Re: SSD-123834490 – Grundy's Waste Solutions Resource Recovery Facility – Review of Planning Application and Submission

JEP Environment & Planning (JEP) has been engaged by Talart Pty Ltd (Talart), the owner of the property at 8-24 Dunheved Circuit, St Marys NSW, to prepare a submission regarding the State Significant Development (SSD) SSD-123834490 'Grundy's Waste Solutions Resource Recovery Facility' (the Proposal). Talart is concerned about the potential impacts of the Proposal on the occupiers of their property, particularly with regard to increases in heavy vehicle traffic and general amenity impacts to the area.

Proposed Overall Site Plan

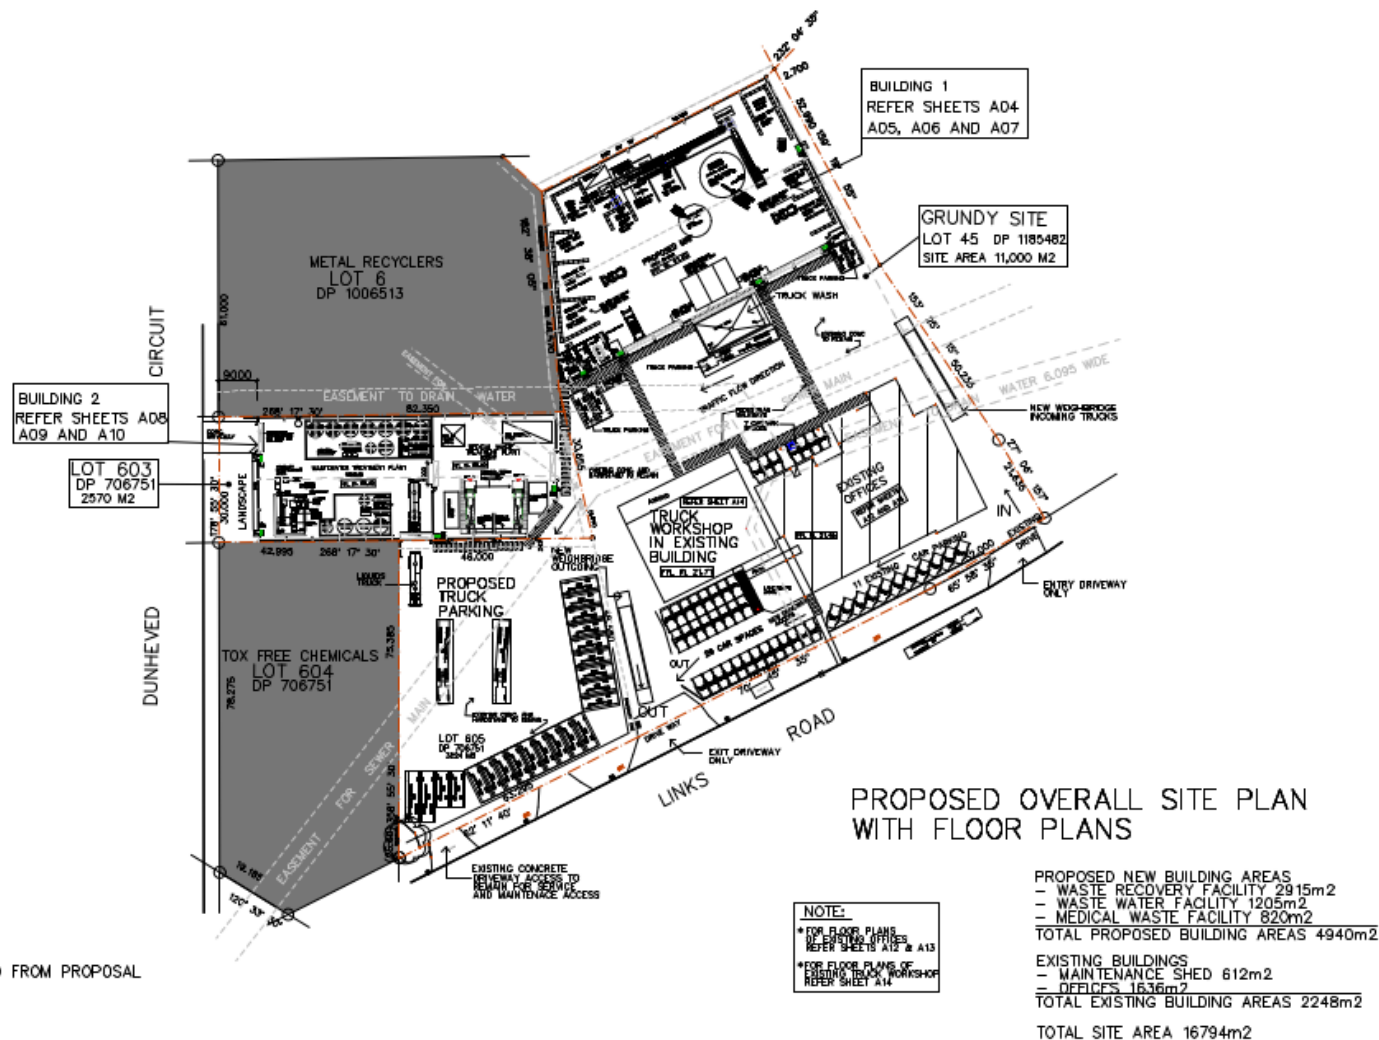
The EIS and TIA are unclear regarding the provision of parking. The TIA indicates a total of 55 parking spaces will be provided, which will adequately cater for the 48 staff members. However, the 'Proposed Overall Site Plan' only includes 47 passenger vehicle spaces. Furthermore, the reliance on tandem spaces may be

- The stack location used in the odour modelling is not consistent with the location shown on the architectural plan set. The architectural plan set shows the stack approximately 32m closer to the eastern boundary than the modelled location. The model should be adjusted;
